Case Ref: EN010119

Date: 22 August 2024

Planning Act 2008 (as amended) – Section 51

Application by North Falls Offshore Wind Farm Ltd for an Order Granting Development Consent for the North Falls Offshore Wind Farm Advice following issue of decision to accept the application for examination.

Scale	Plot Size	Datum	Projection
1:50,000	A1	WGS84	UTM31N

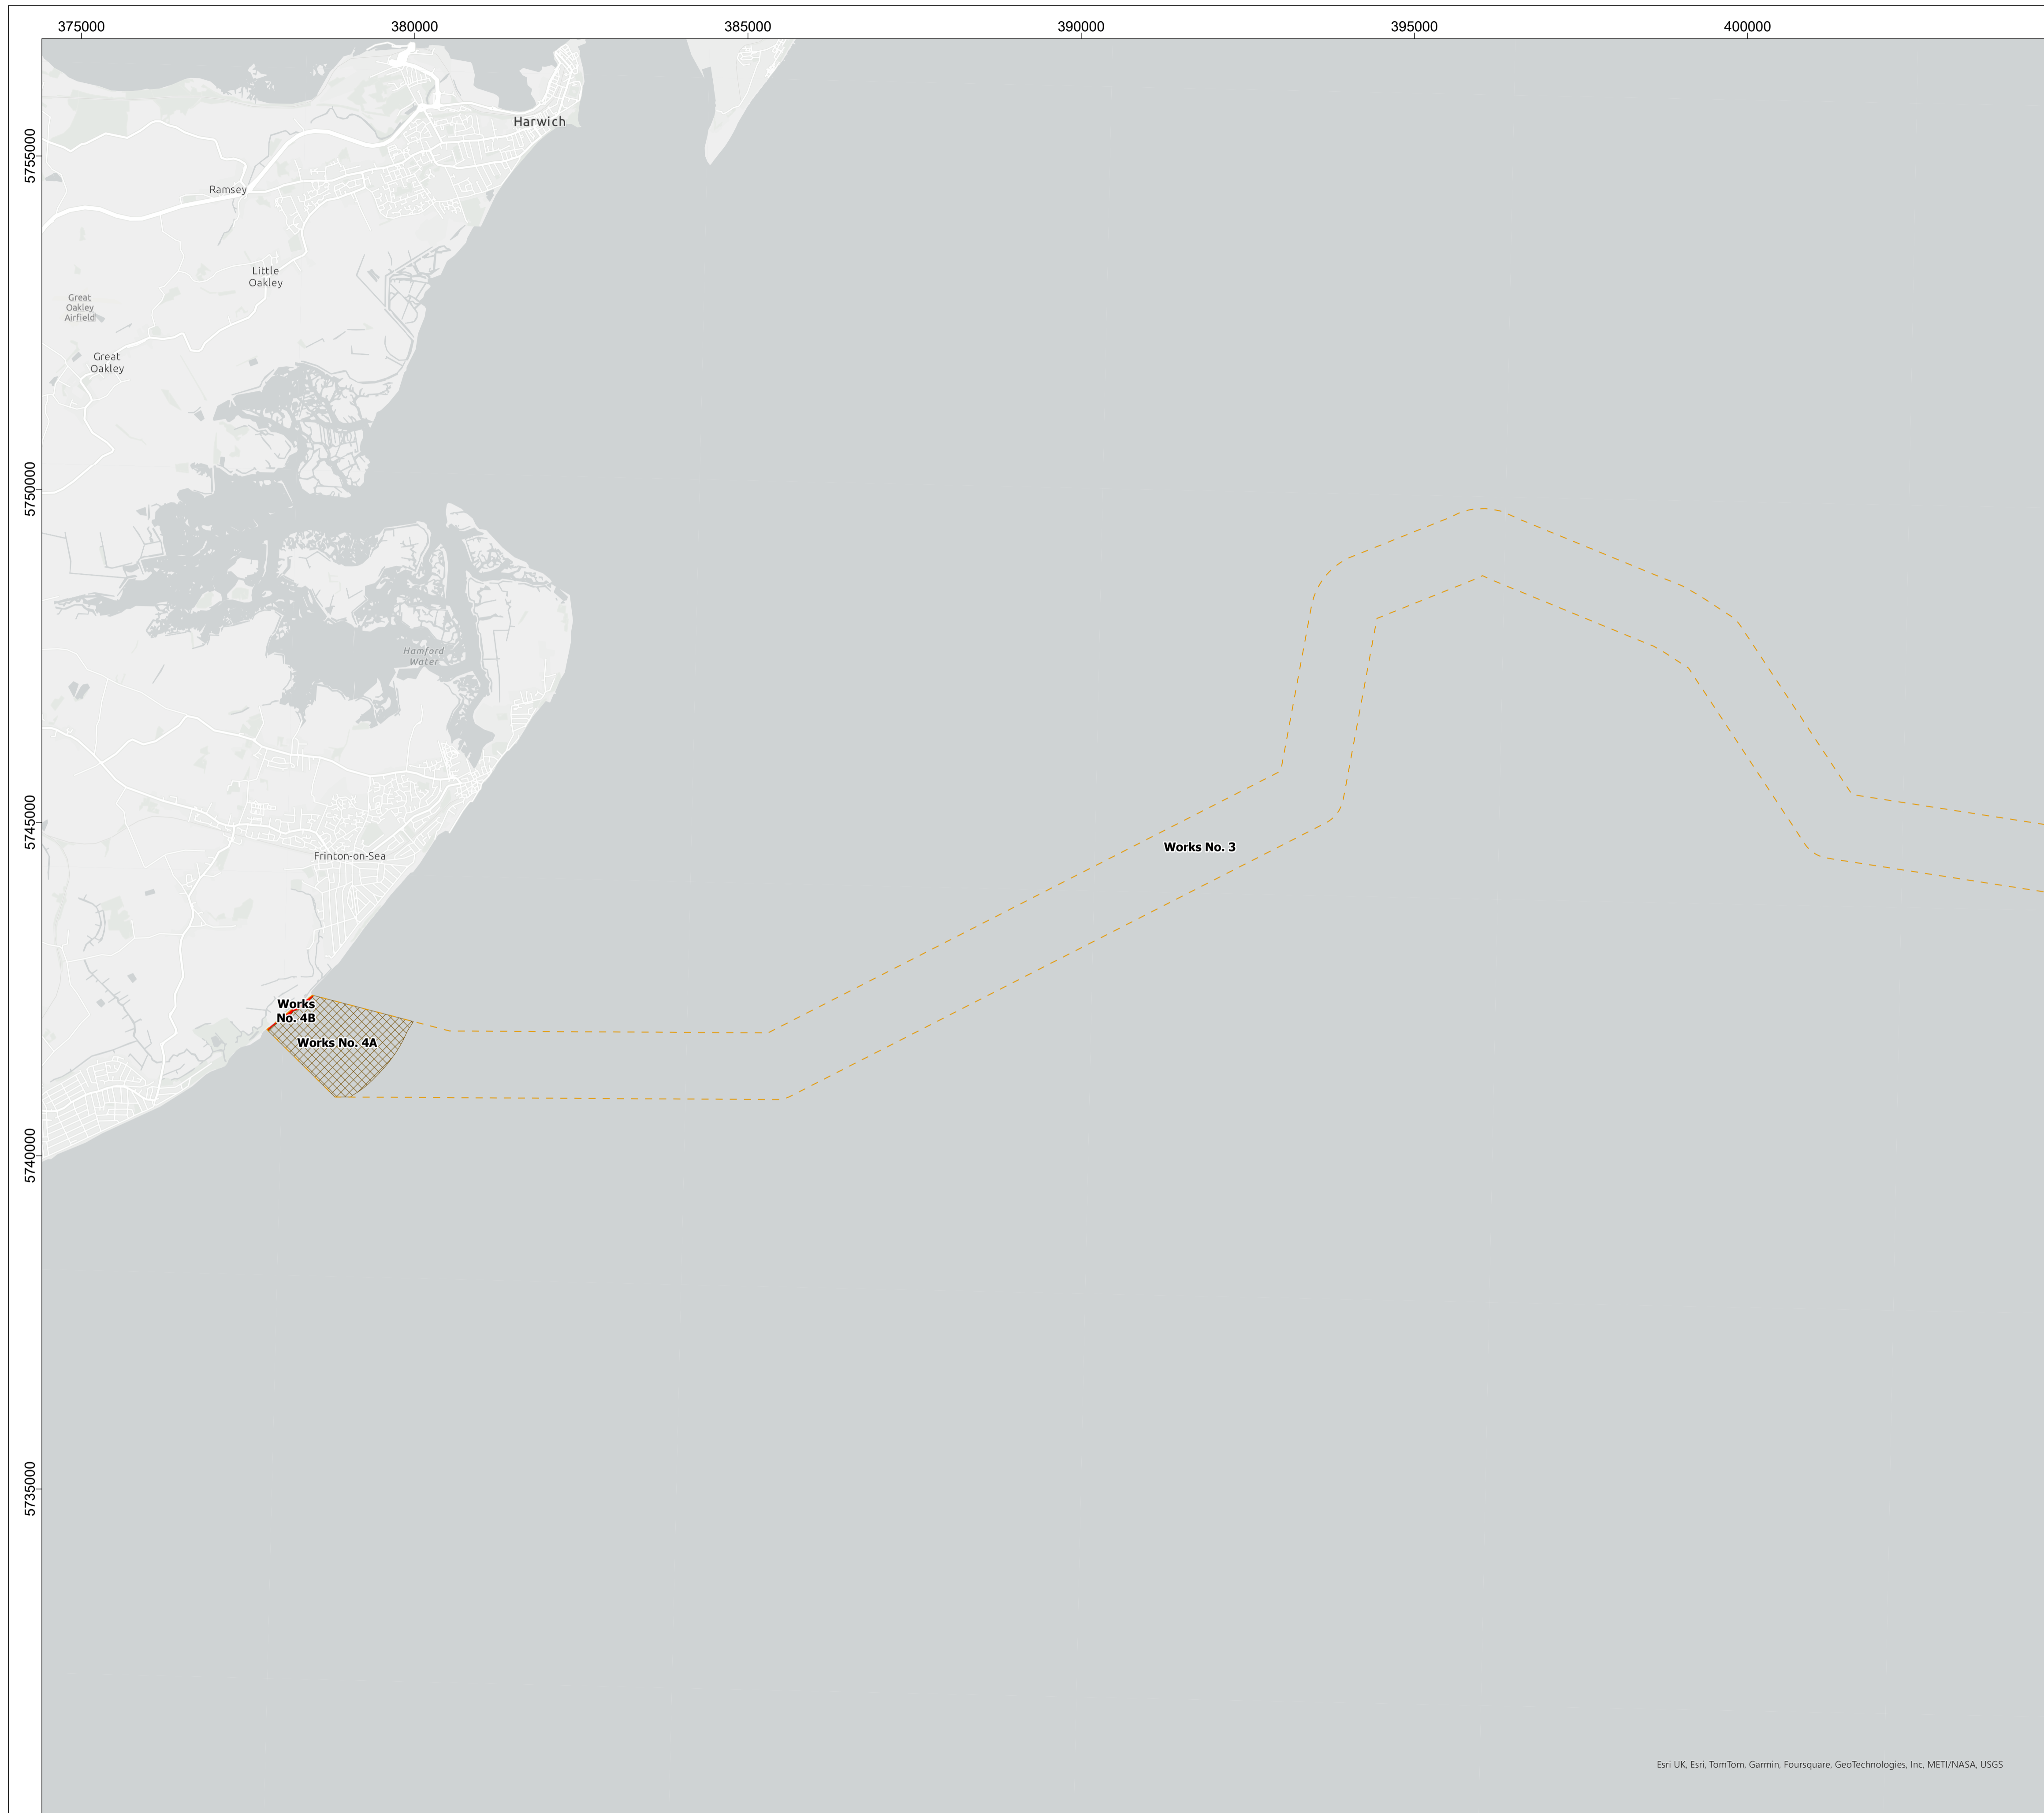
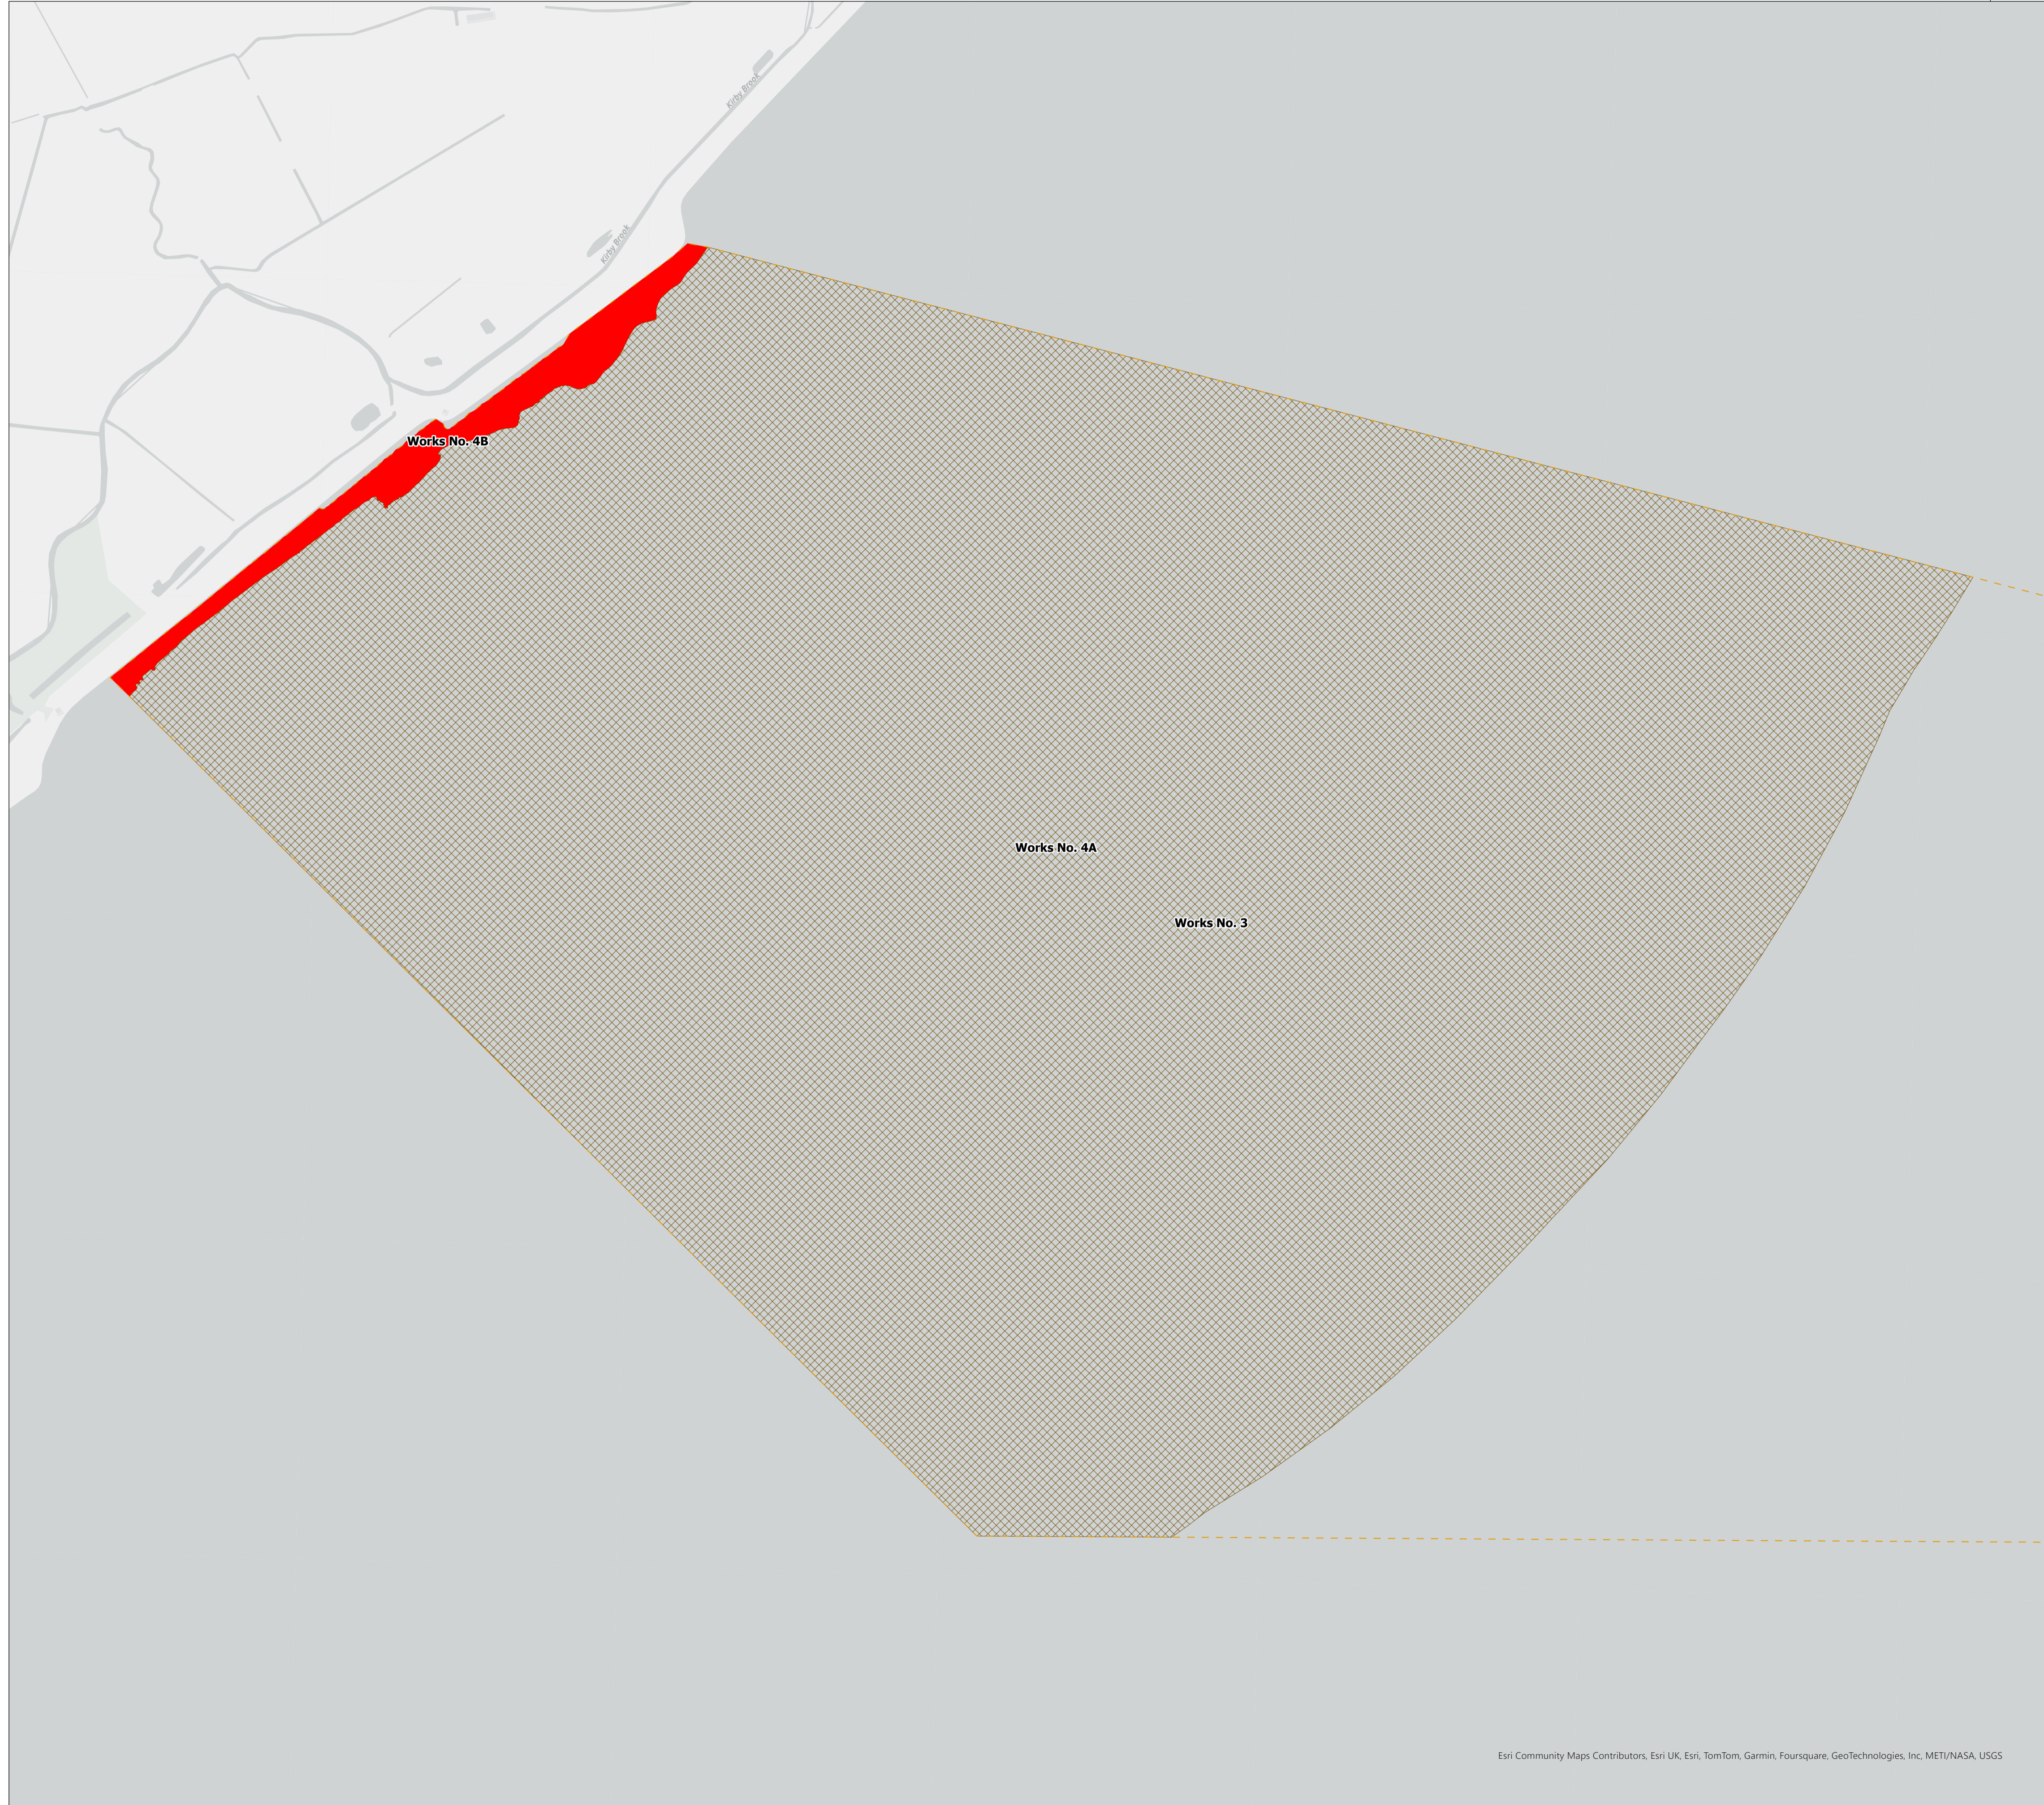
Summary descriptors are not provided for each work area. Location Plan Offshore (Doc. 5.2) includes a background reference map, however this is missing in the Works Plan Offshore (Doc 5.7). Adding summary descriptors and a background reference map would aid understanding for stakeholders. Once summary descriptors are added to the plans, please ensure that these can be digitally searched. This should be provided to the Planning Inspectorate for publication as early as possible before the commencement of the Examination.
